MMC meeting 2/8/18 Brief notes/action

Jean Fraser, Planner
City of Portland
874 8728

SHEET NUMBER
A20-02

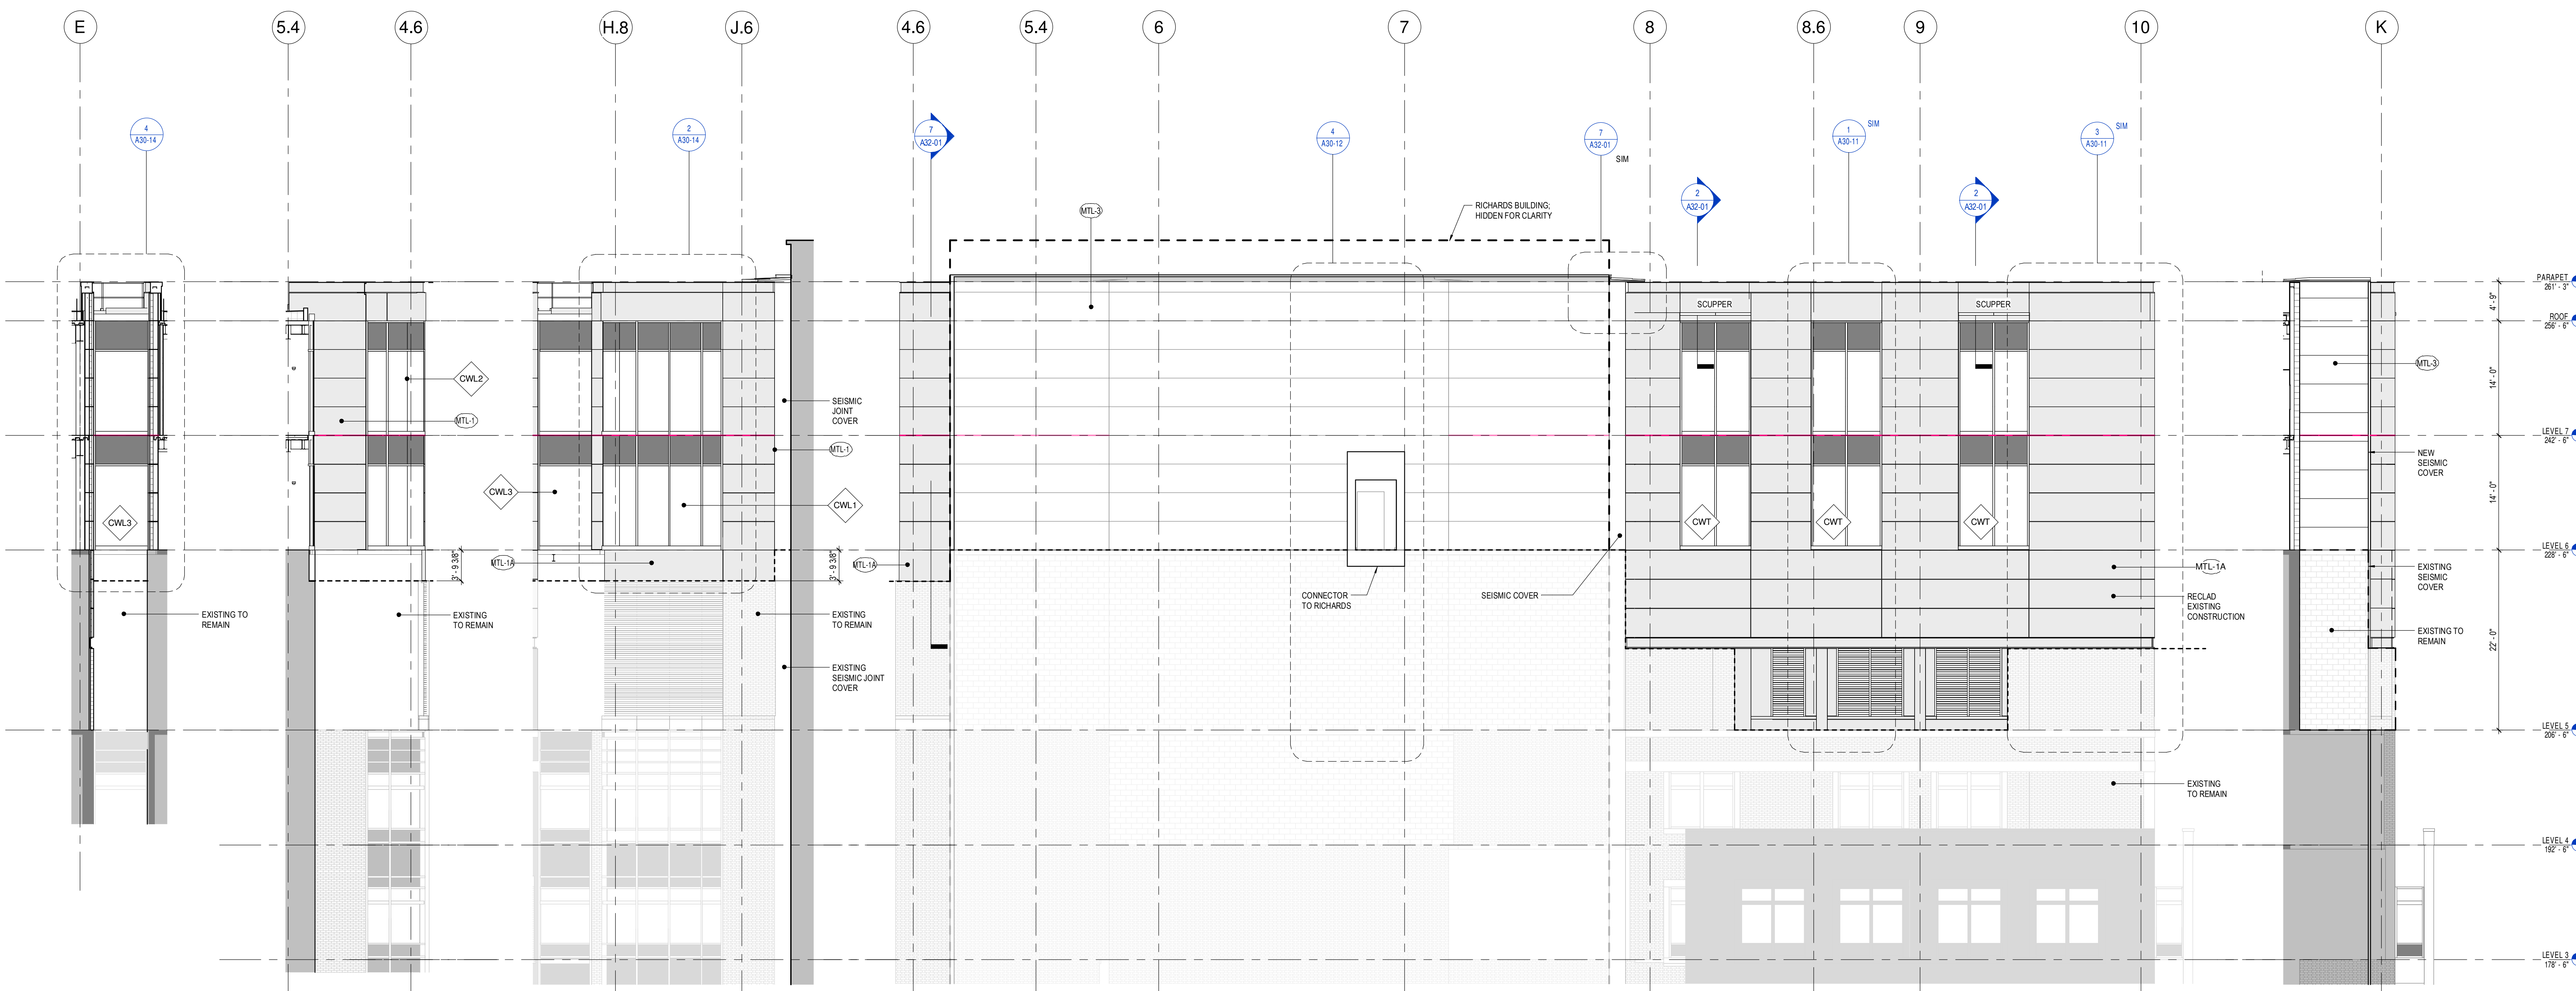
- JK from Perkins & Will showed more detailed rendering of ET and clarified where there was "white" on the existing buildings that relate; consider white best for a number of reasons; not done a rendering with silver nor with white cladding brought down
- Discussion of whether white of the new will match existing- not feasible to reclad existing white; MMC explained had looked at options for tone of upper cladding
- Discussion of how ET overbuild will integrate with new hospital building and agreed rendering of latter to show Board
- Discussion of VG and question of adding visual interest (viewed new renderings of proposal from Congress); MMC had considered options but not revised proposals due to constraints
- VG Retail space being fitted out for Turners with long term use in mind- CC suggested this be clarified to Board

- CC and JF suggested that MMC needs to address Board comments on both buildings in some way and to explain what other options have been considered prior to finalizing current option
- MMC clarified glass specs for both ET new windows and VG tower at E end
- CC asked for info re the following and to be submitted for Board:
 - glass specs
 - all materials
 - shades to be used inside ET rooms
